Application for Planning Permission

Development: Installation of an external passenger lift. Is in CIL Zone 4 (Zero Rated) as other development.
Location: Heath Place Ash Grove Bognor Regis PO22 9SH

Block Plan - Heath Place, Ash Grove, Bognor Regis, PO22 9SH

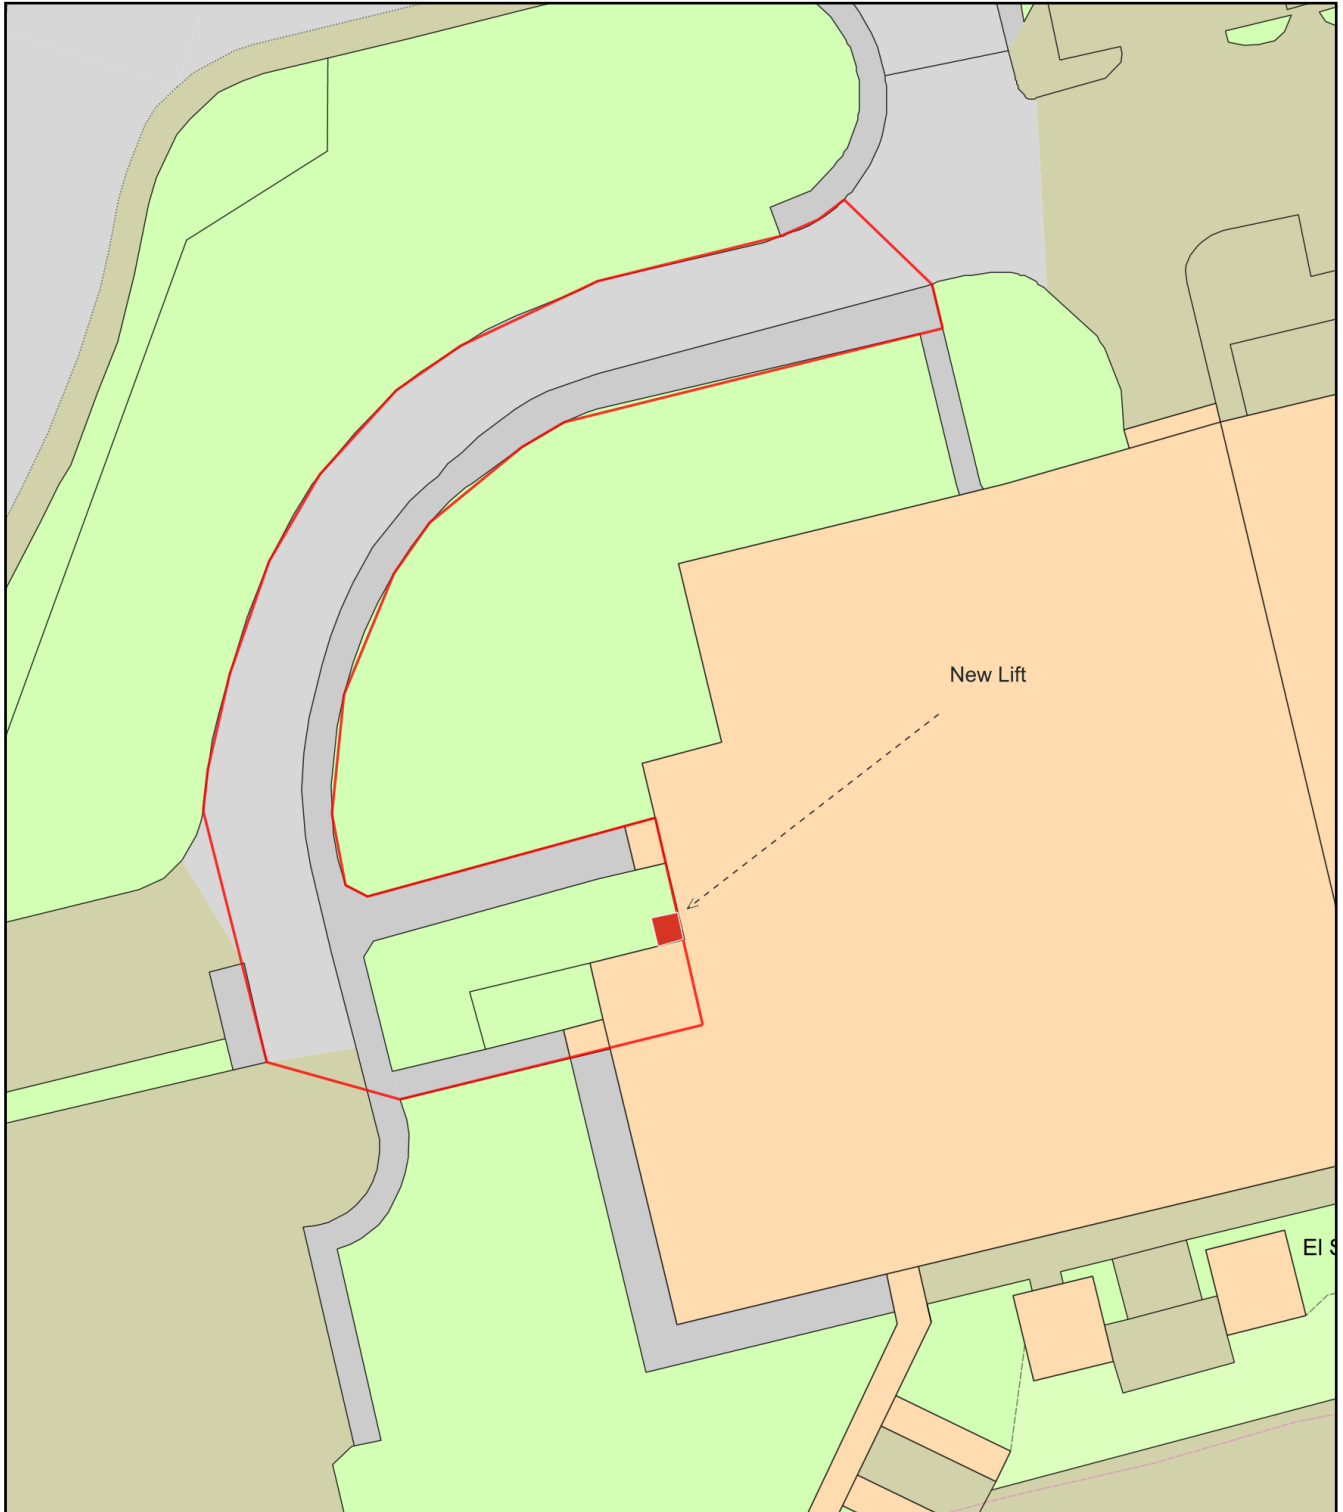
Please submit an electronic block plan showing the lift's position by highlighting or hatching in pdf format at a scale of 1:500. Further details of what must be included on the plan can be found in the Validation Requirements List.

# Site Location Plan - Heath Place, Ash Grove, Bognor Regis, PO22 9SH

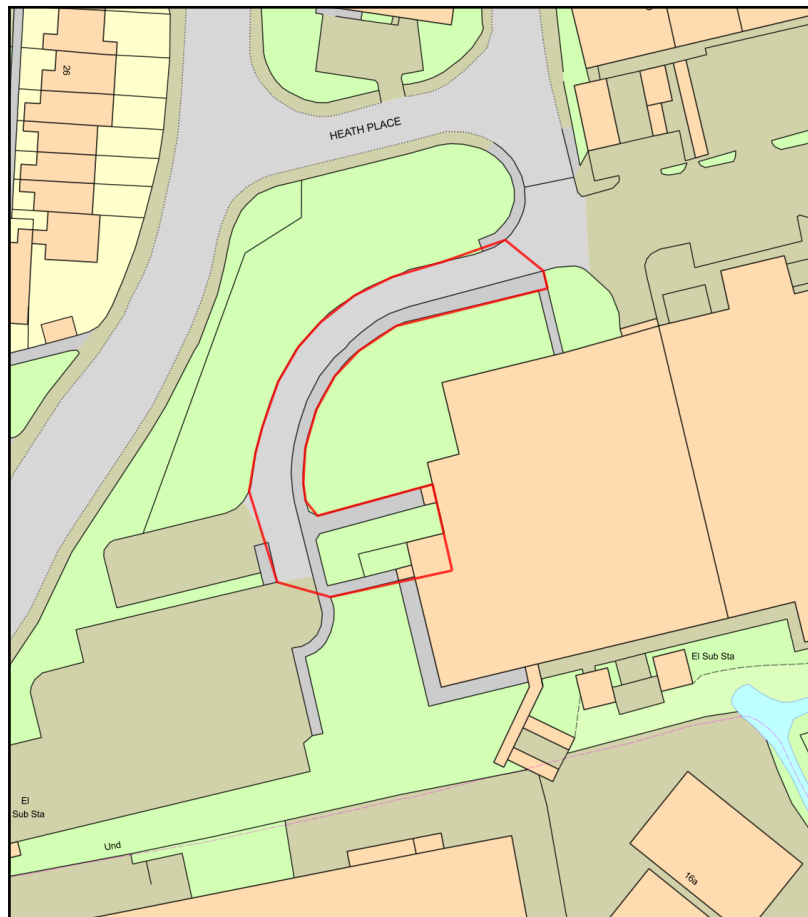
The location plan is not measuring correctly, please amend.
